Engineers Comments Regarding Surface Water Drainage

Application No: BN/18/22/DOC
Registered: 23rd February 2022
Site Address: The Cottage Highground Lane Barnham PO22 0BT
Description of Works: Approval of details reserved by condition imposed under ref BN/17/21/PL relating to Condition Nos 3 - materials and finishes, 5 - Construction Management Plan, 9 - Energy Statement, 13 - surface water drainage, 14 - foul water disposal, 15 - Biodiversity Enhancement Plan.

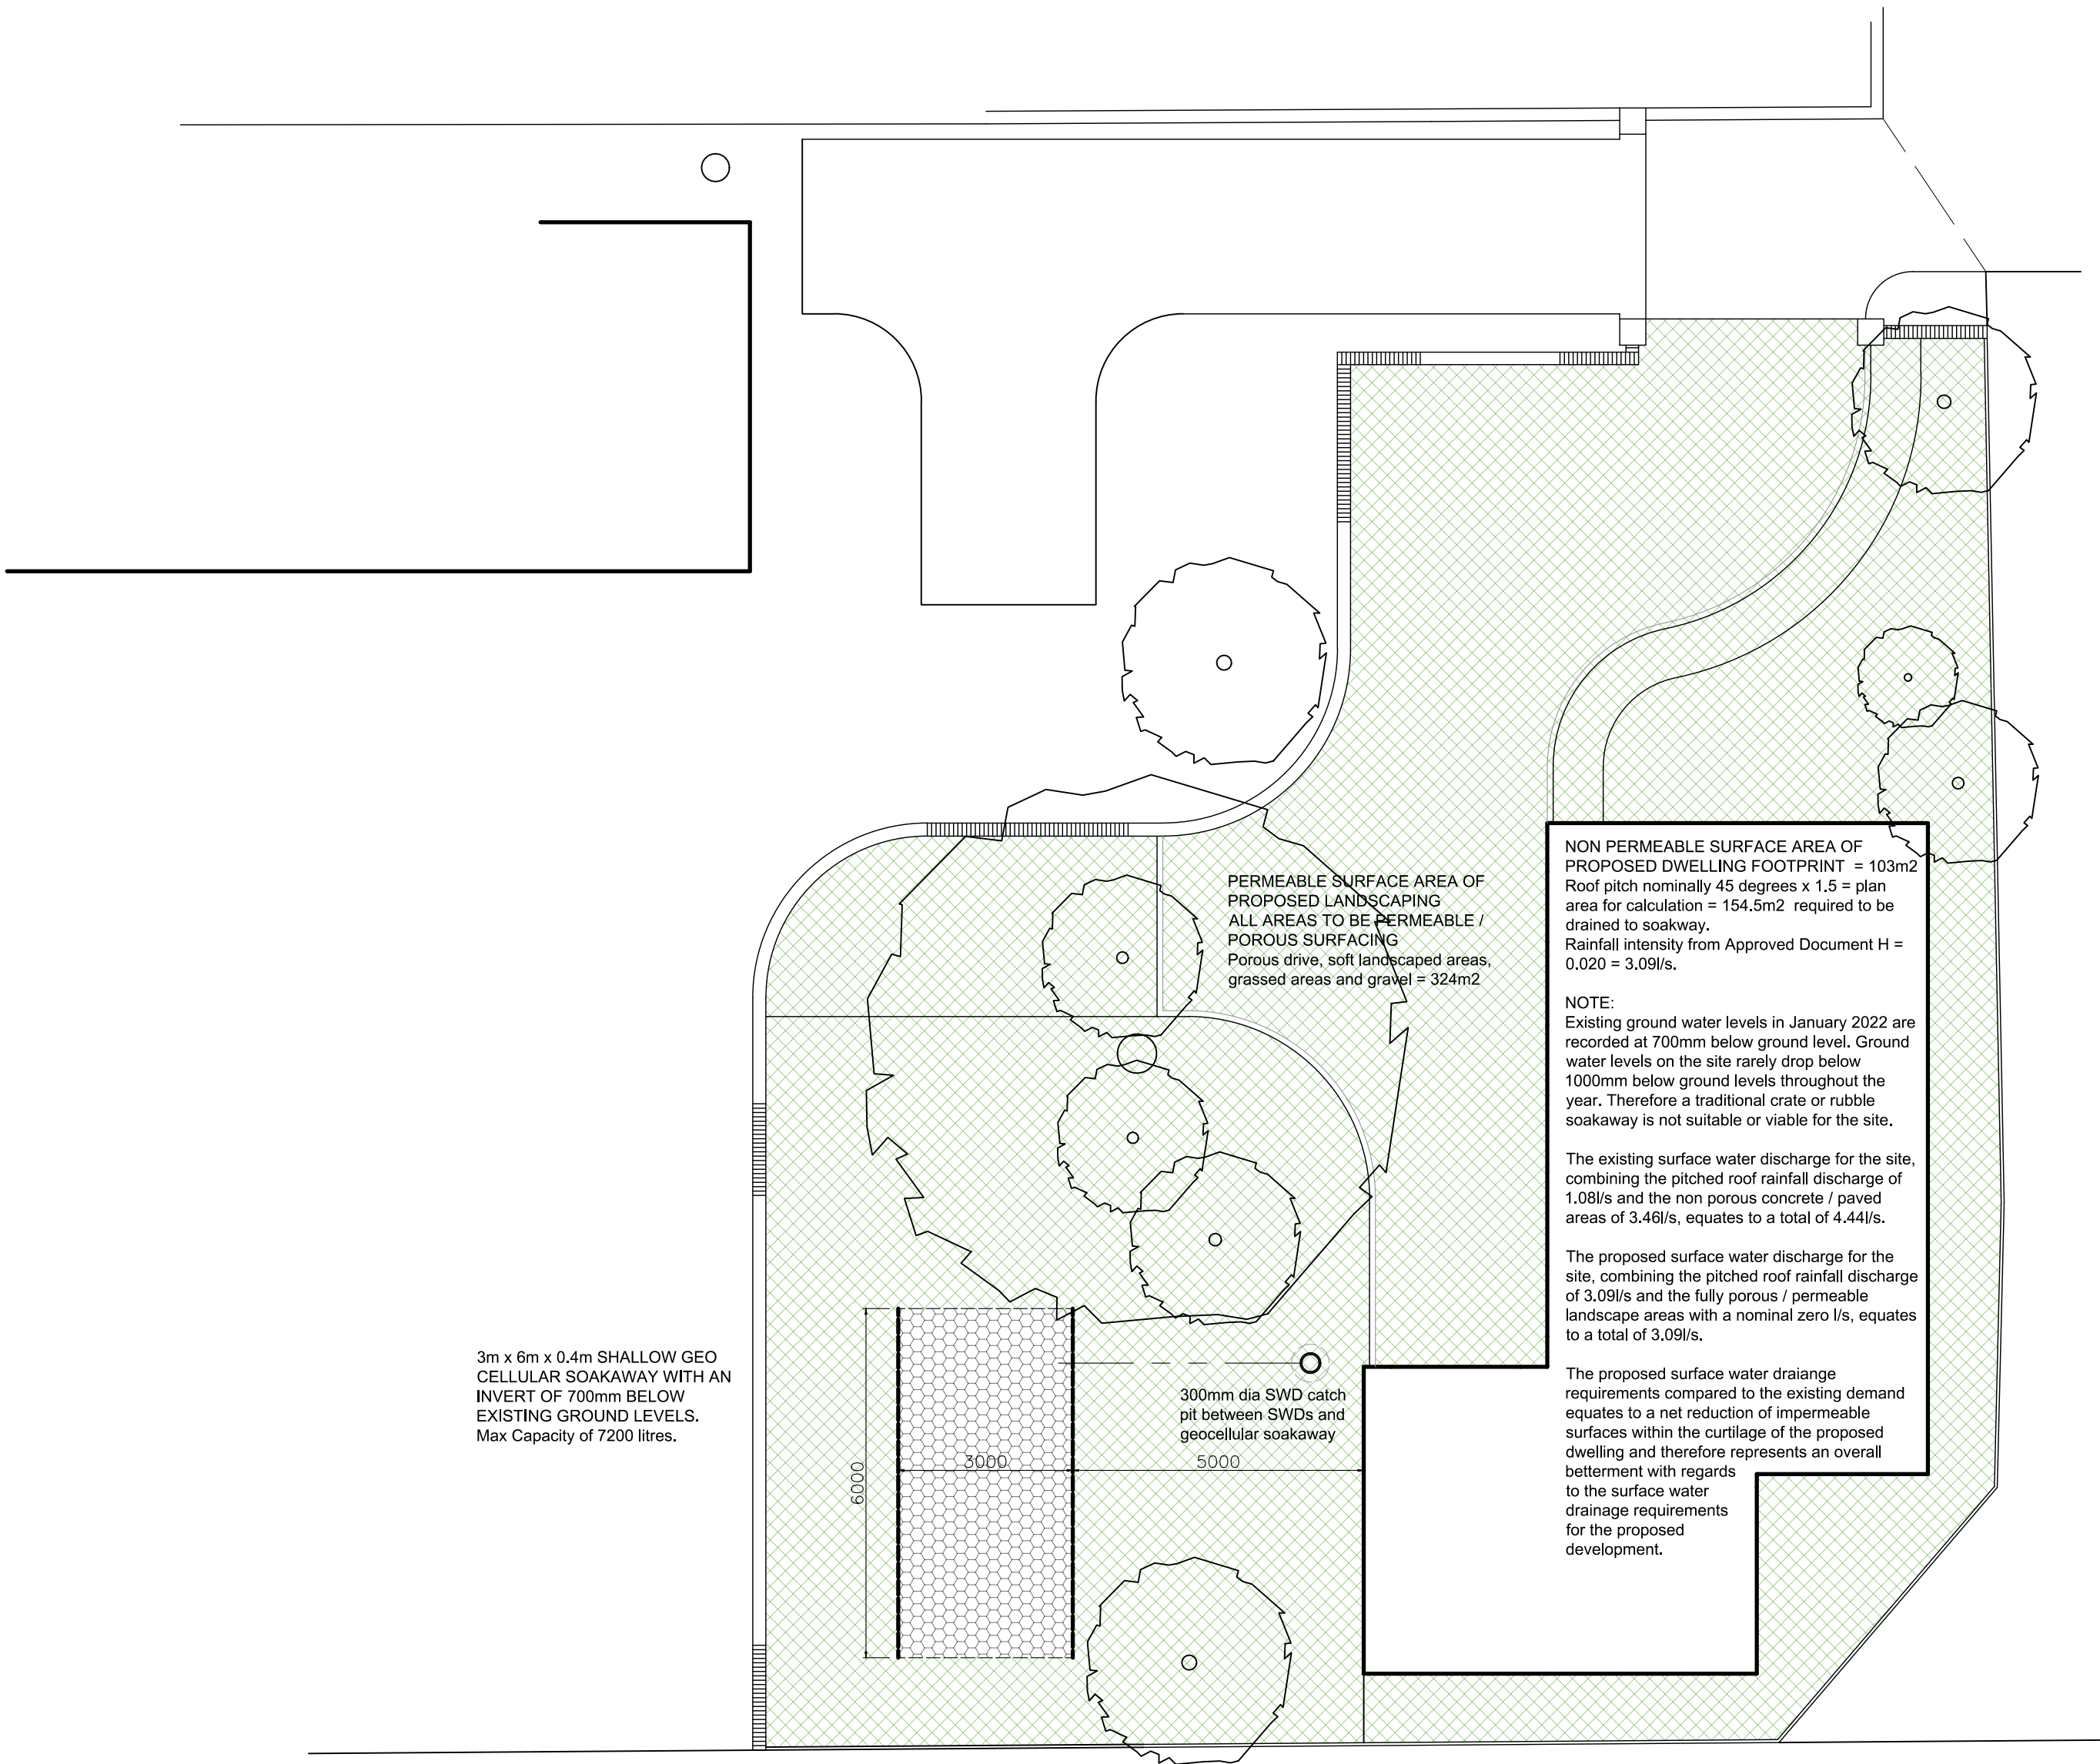
The applicant has supplied a SWD Design Layout Dwg which gives an indication of the proposed strategy. They have also provided a surface water drainage statement which attempts to justify the design.

If the owners of Russet Cottage are agreeable to the use of their data then the applicant will need to submit an updated design, calculations and construction detail drawings. Any reference to the previous use of the site is irrelevant, they will need to design the surface water drainage for the new dwelling to meet current requirements.

It is worth pointing out at this stage that the new design must not locate the soakaway within any tree root protection zones. The current proposed location would be unacceptable for this reason.
